Paint Brush Hills Filing 13E  
PCD File No: SF 189  
Traffic Impact Analysis  
(LSC #184670)  
September 28, 2018

RE: Paint Brush Hills Filing 13E  
PCD File No: SF 189  
El Paso County, Colorado  
Traffic Impact Analysis  
LSC #184630

PAINT BRUSH HILLS FILING NO. 13E
CONSTRUCTION PLANS
KEY MAP WITH SIDEWALK LOCATIONS
INCLUDING TYPICAL ROAD SECTIONS

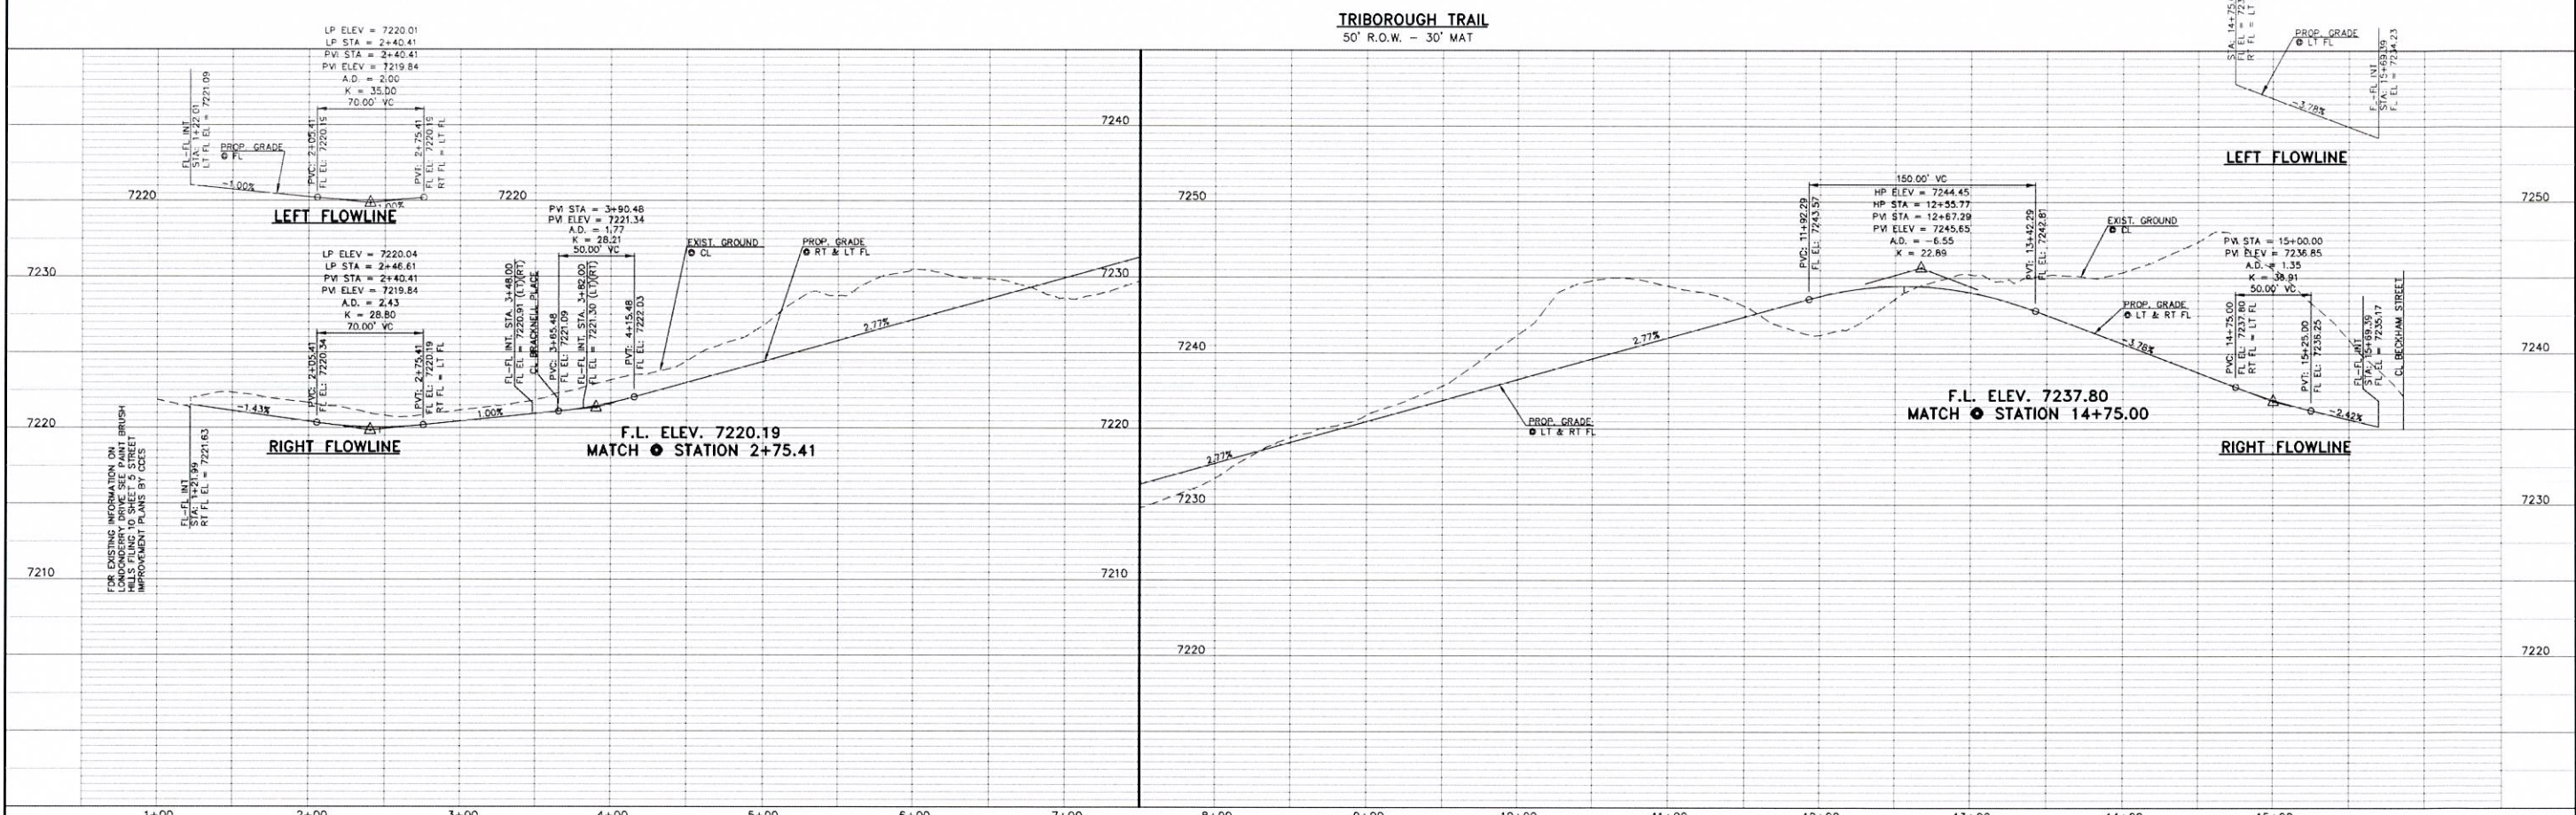
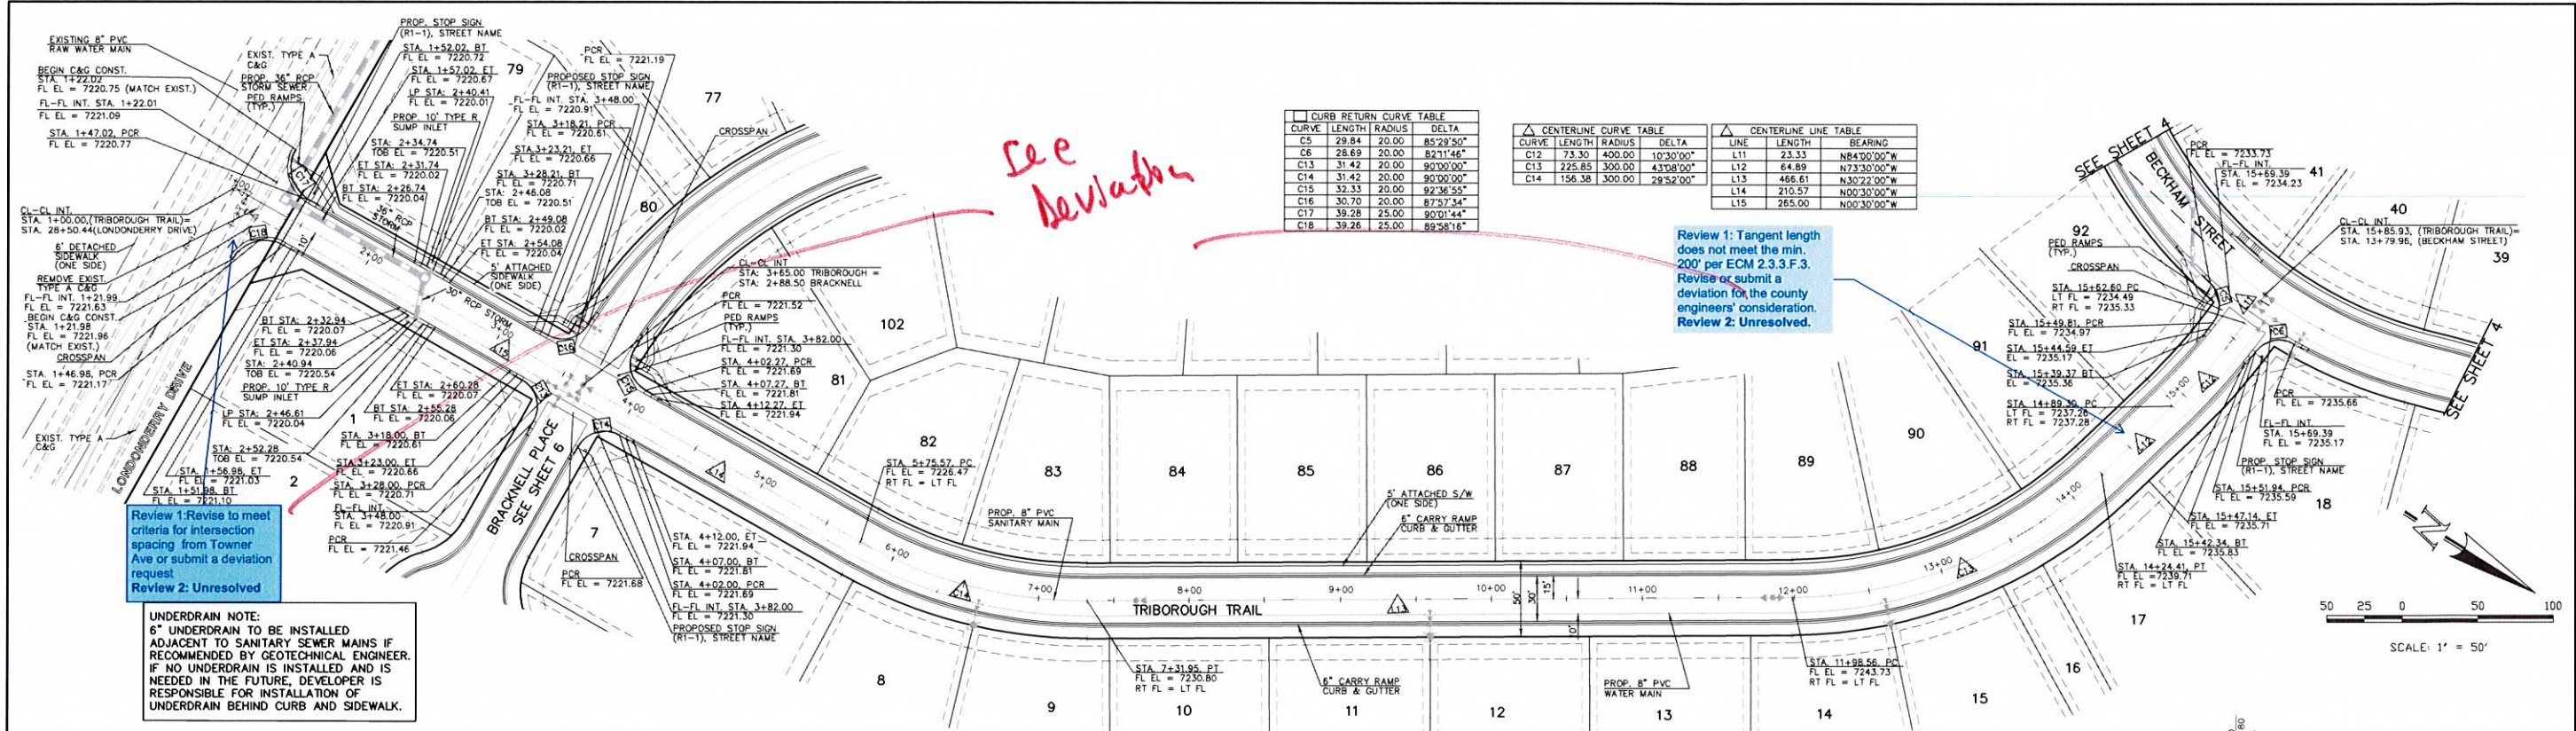
There seems to be a disconnect with the construction drawings. The projected short-term and 2040 construction drawings and plat identifies Keating Drive and Asbee as a Residential Collector.

section (pg 4). of the site access intersections to Londonderry Drive are projected to operate at LOS B or 1. Did PBH Filing 11 intend Keating Drive to be a collector road? This results in a collector road that does not seem to connect to a similar or higher road classification.

2. Based on future filing 14 to the west, should Devoncove Drive be constructed as a residential collector?

All of the Paint Brush Hills Filing 13E internal streets should be classified as Urban Local.
